**WELWYN HATFIELD COUNCIL – DEVELOPMENT CONTROL**  
**DELEGATED REPORT**

<b>APPLICATION No:</b>	<b>S6/2007/1207/FP</b>
------------------------	------------------------

The application seeks full planning permission for the reconfiguration of the existing first floor accommodation which is currently contained wholly within the roofspace.

Project 57 The Ridgeway Cuffley
 Drawing PROPOSED Plans and Elevations
 Date July 2007
 Scale 1:50 1:100
 Drawn DT 8529/P/002

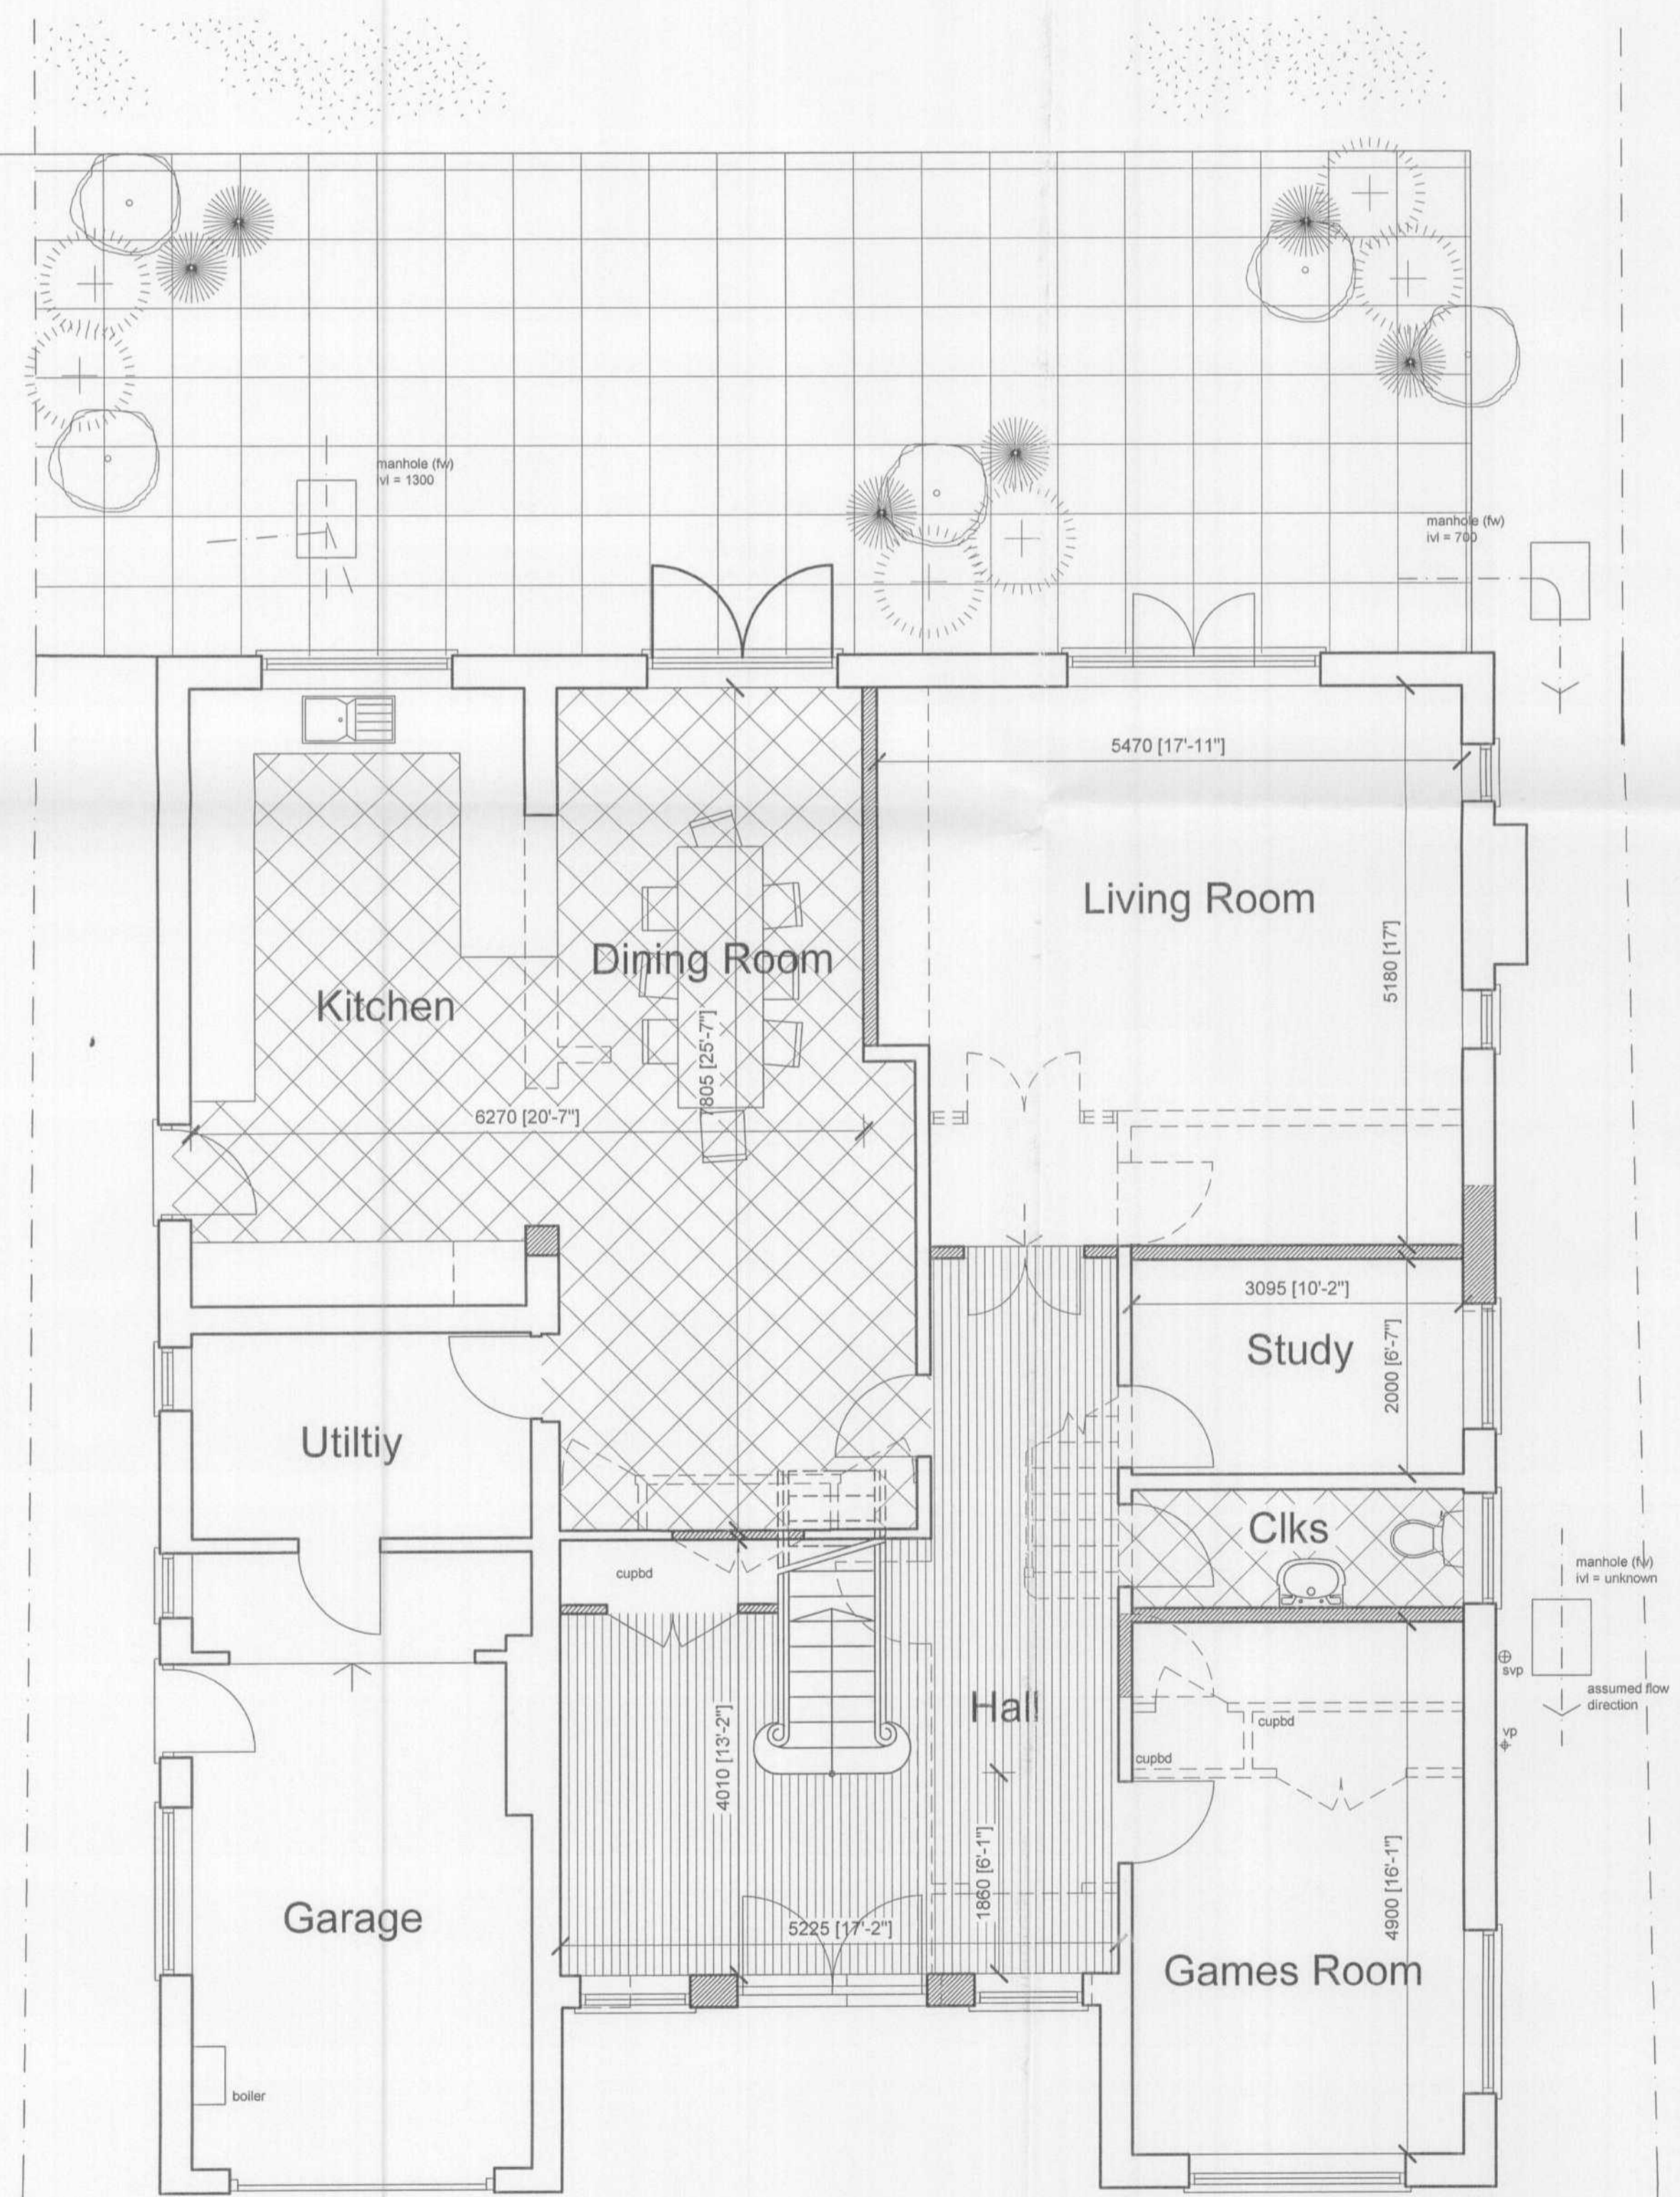
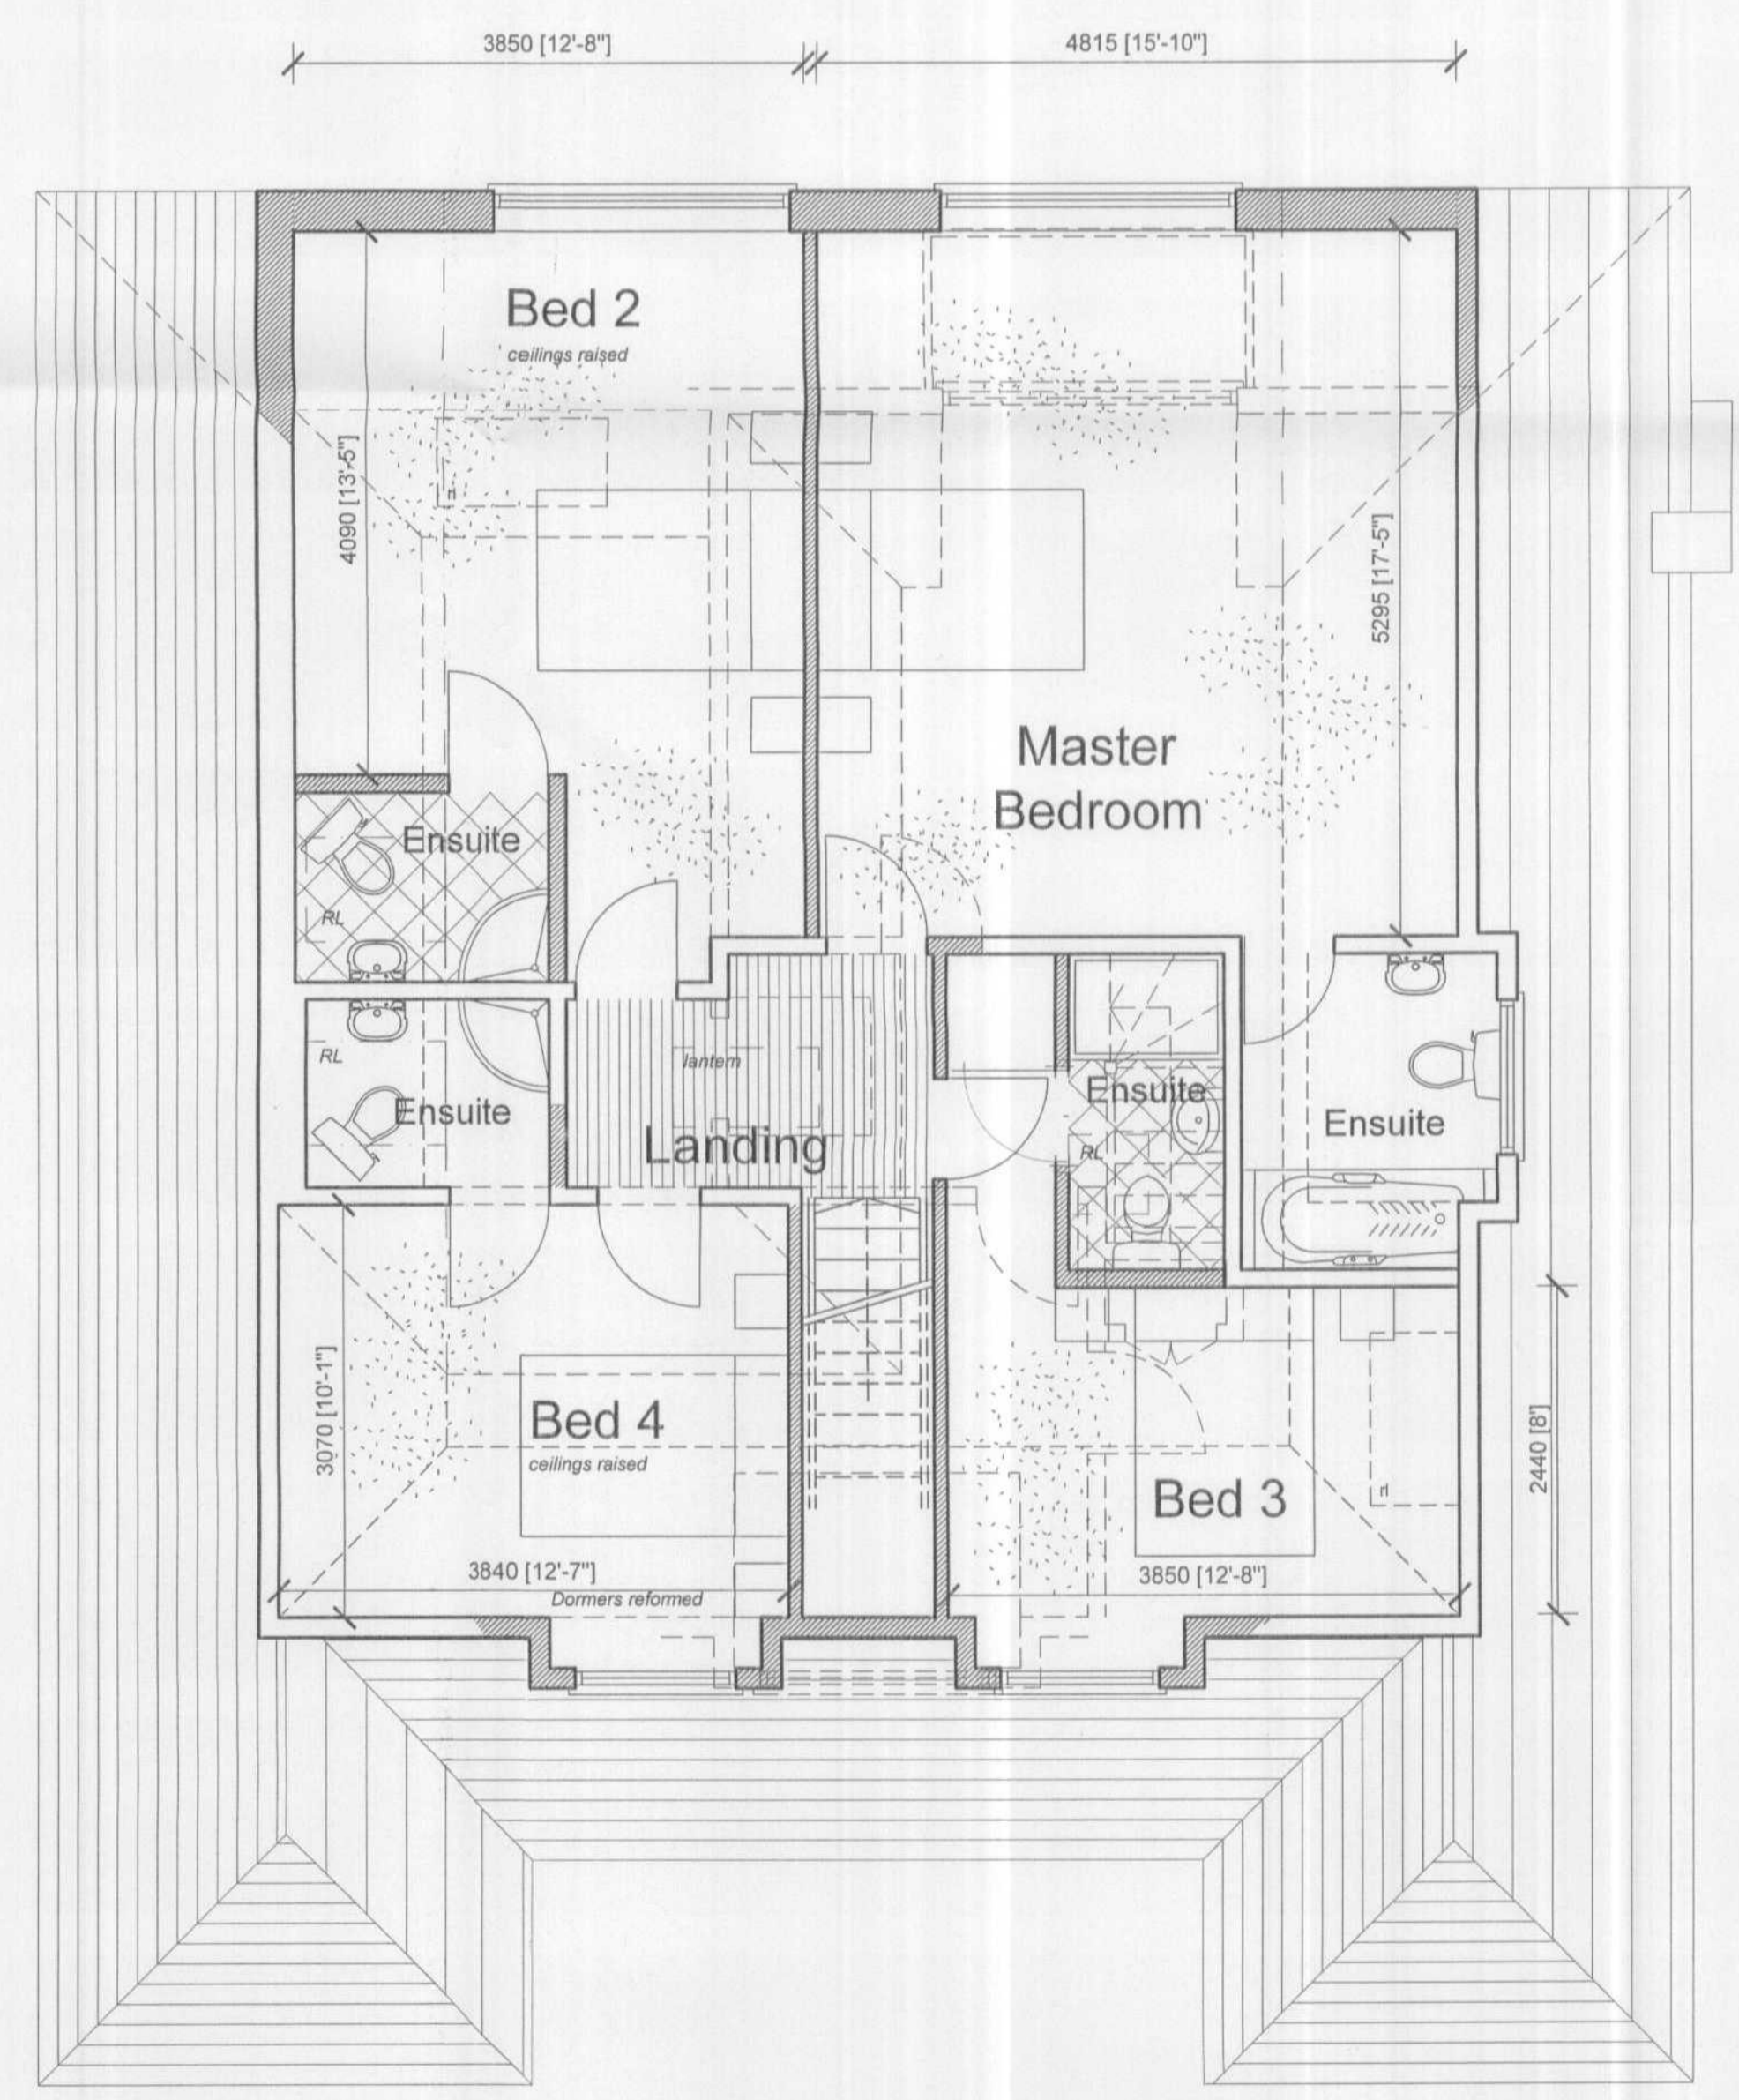
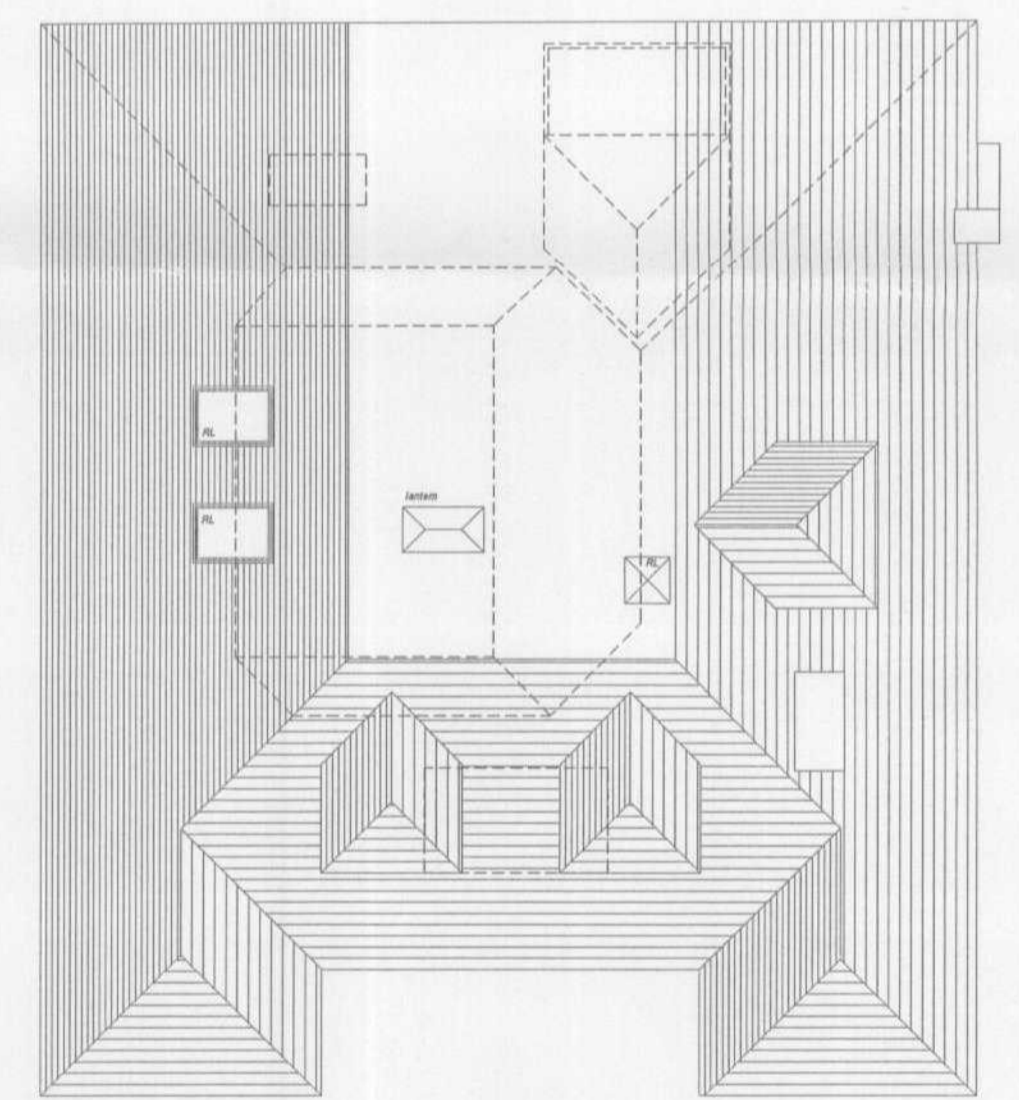
The extent of the changes is likely to require the complete removal of the roof to allow the increase in headroom and for the addition of a fourth bedroom. The original footprint of the building is to remain unaltered and the height of the new ridgeline is to be slightly lower at approximately 7.3m compared with 7.7m. The new first floor accommodation will also be contained wholly within the roofspace, apart from the introduction of a new rear gable wall.

The proposal would still use the resultant roofspace for the new first floor accommodation, albeit in reconfigured style. The main visual impact would result from the new rear gable wall. However, when taking into account that the height of the new roof would be slightly less than the original and that the increase in bulk and mass would still be proportion, the overall impact on the openness of the Green Belt would be acceptable.

In regards to the new roof, a side dormer is proposed for an ensuite bathroom which would look towards the flank wall of No.59 which also has 2 small flank wall first floor windows. Bearing in mind that a dormer already exists in a similar location and that the new dormer can be conditioned to have obscure glazing and being incapable of opening below 1.7m, it is considered that this would not result in any loss of privacy to the adjoining neighbour.

In regards to the rooflights, these serve ensuite bathrooms and bedroom 3. All these can be conditioned in a similar manner as the windows to the bedroom is only a secondary one.

Turning to the impact of the proposed increase in mass and bulk, this would have limited impact on the amenity of the adjoining neighbours at No. 55 & 59 as the increase in roof height is slight and the rear gable wall would not extend significantly beyond the rear elevations of these neighbouring dwellings. The proposal would therefore not appear unduly over dominant or over bearing to Nos. 55 & 59.

3. Other than the windows shown on the approved drawings to which this planning permission relates, no windows (including rooflights) shall be inserted into the new side roof slopes of the extension hereby permitted without the prior written consent of the local planning authority.

4. The proposed first floor side dormer and 3 rooflights in the side roof slopes of the proposed building shall be glazed with obscured glass and shall be fixed so as to be incapable of being opened below a height of 1.7 metres above floor level, and shall be retained in that form thereafter.
